## Summary of the Written Representation from Paul Griffiths

Road noise reduction, reference 6.1 Environmental Statement, Chapter 11 Noise and Vibration

FIGURE 2.5  
HAZLEGROVE JUNCTION UNDERBRIDGE  
GENERAL ARRANGEMENT

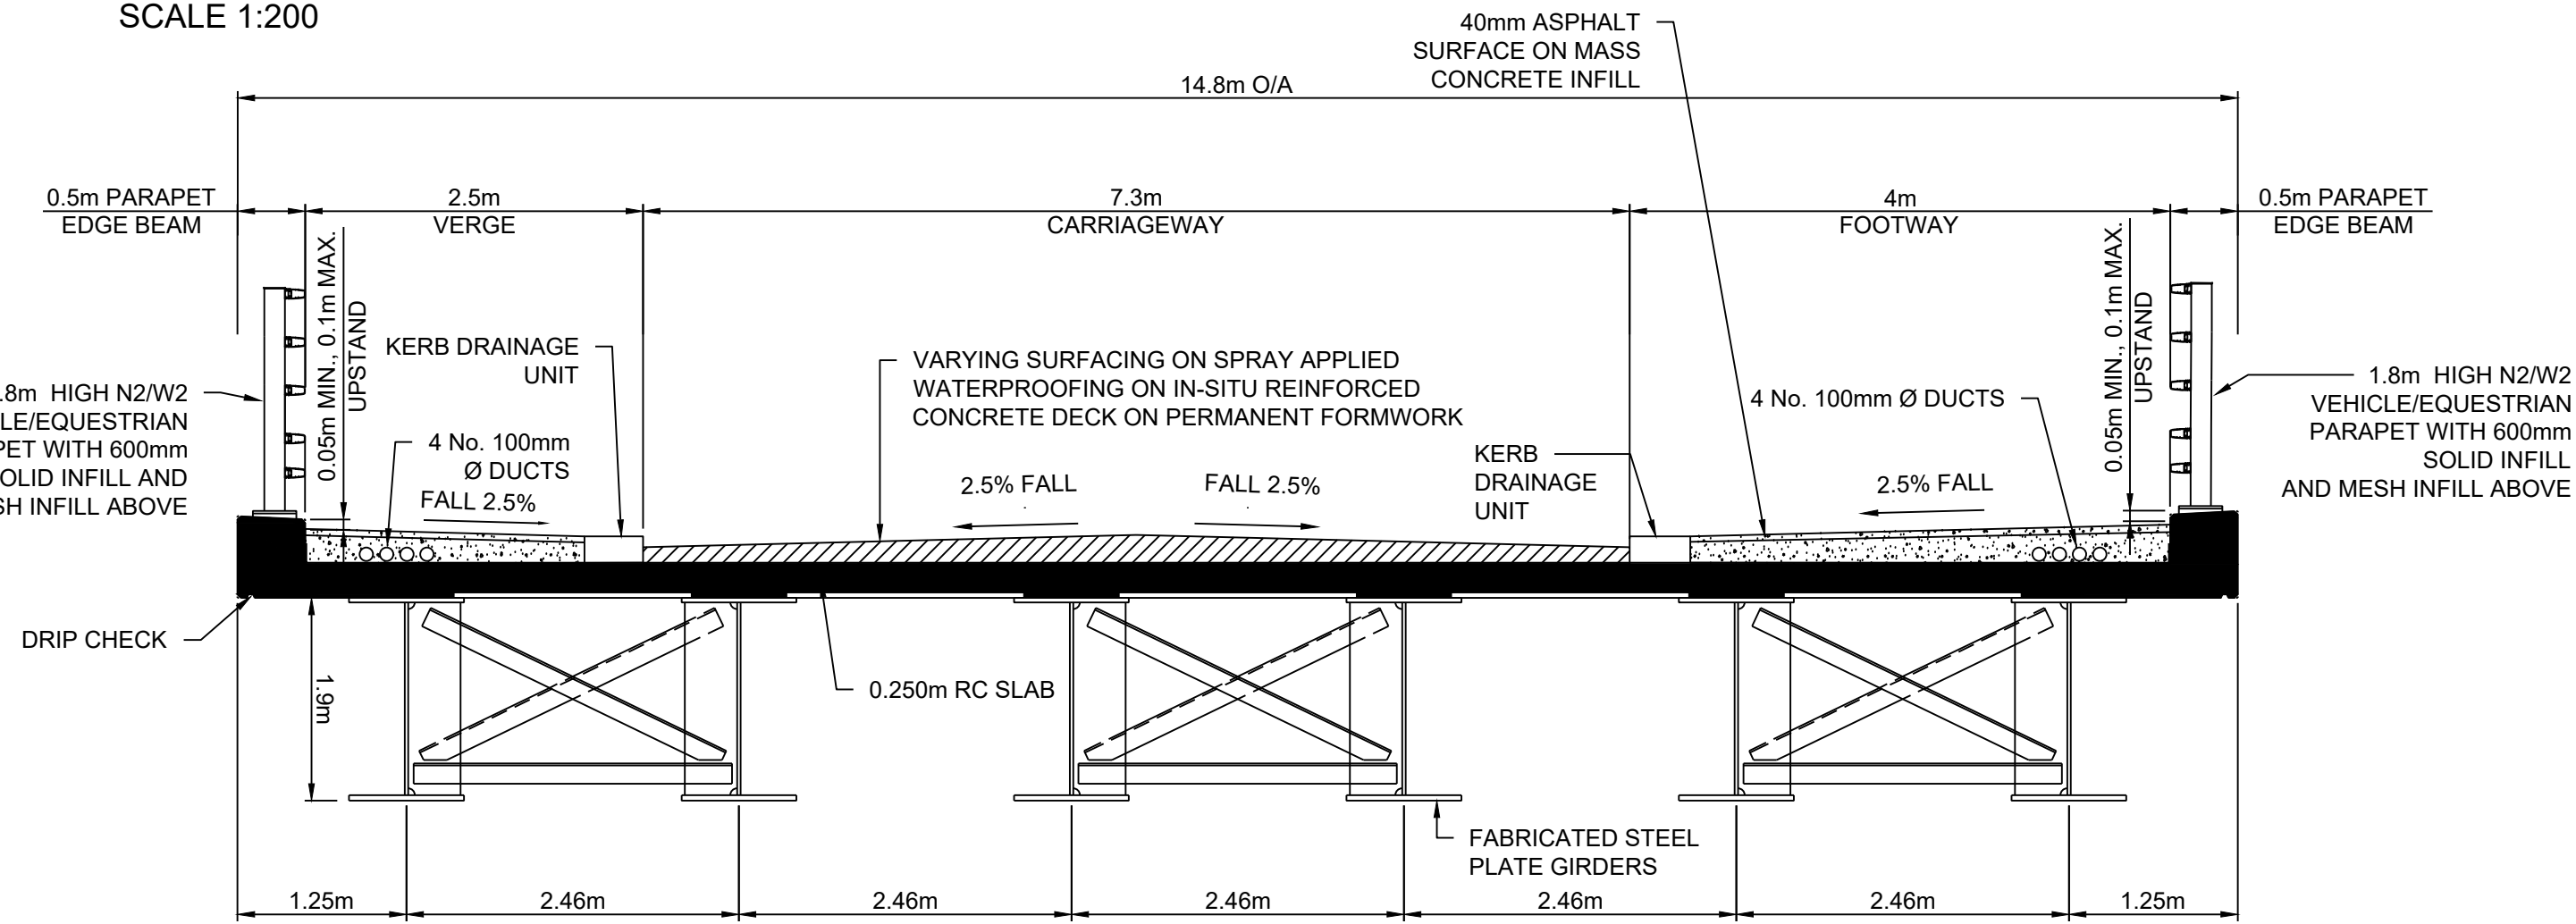
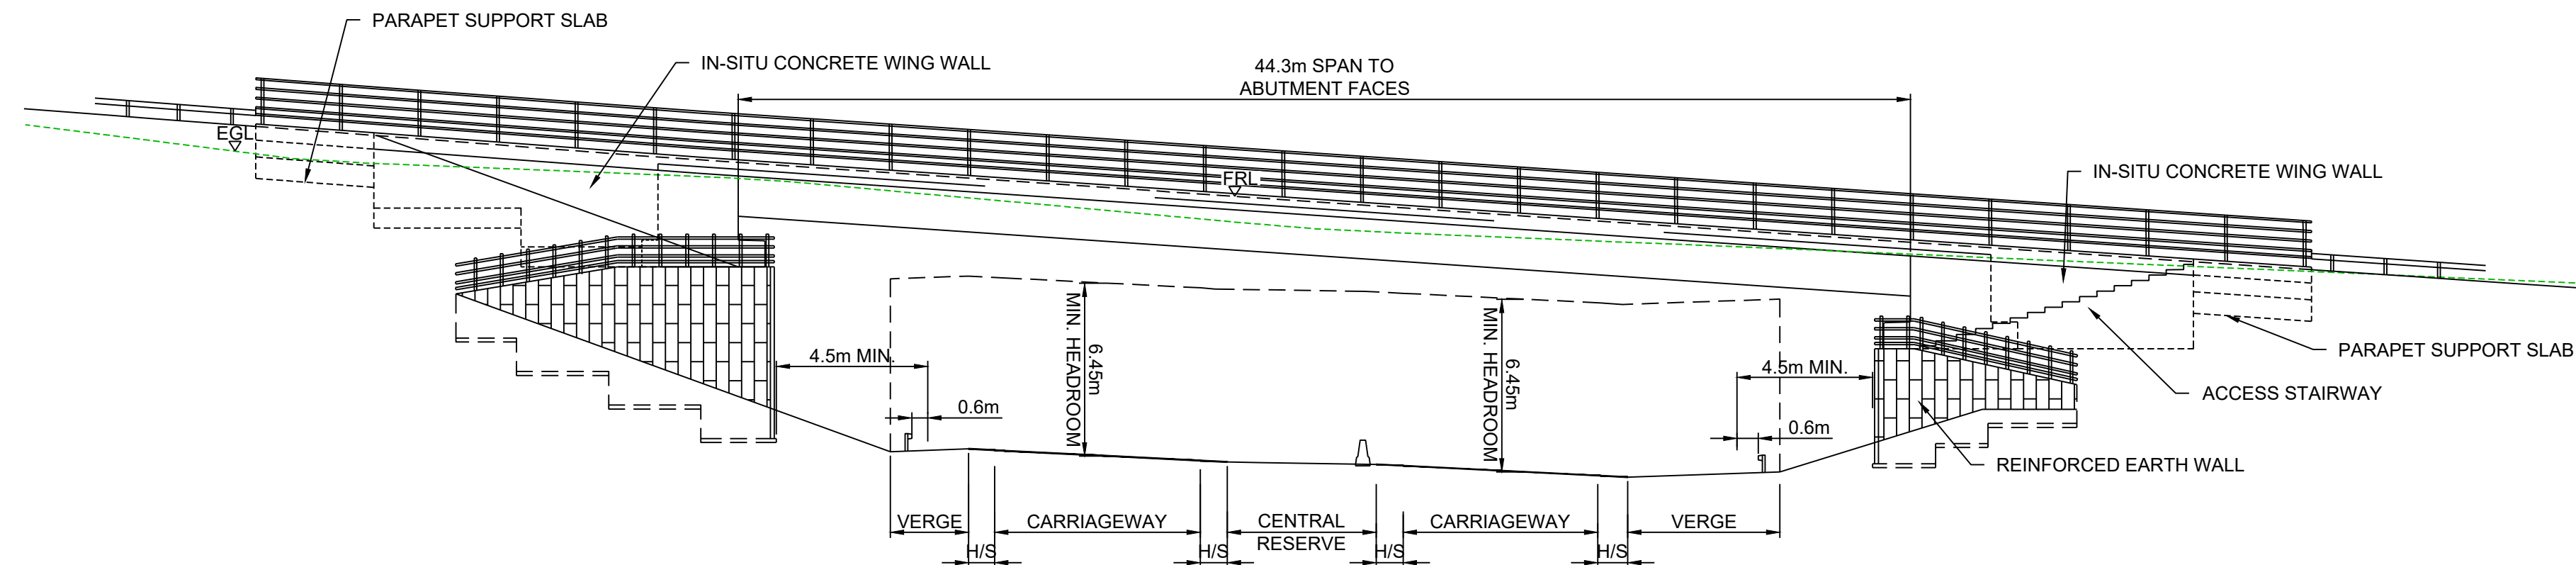
Para 11.9.1 identifies bunds and cuttings but in fact with the elevation of the road at Hazelgrove Junction there is effectively no effort to achieve noise reduction from bunds and/or cuttings to the south side around Sparkford.

If 10dB, why is the effect of the 4m wall on the A303 (very close to the vehicles making the noise) only worth 1.2dB at Wolfester Terrace? What about a concrete wall (required to hold vehicles onto

the elevated road) with noise attenuation (wood or metal? for reflection/absorption) element added in front of and/or above the wall? I believe that the M40 and M3 have these devices
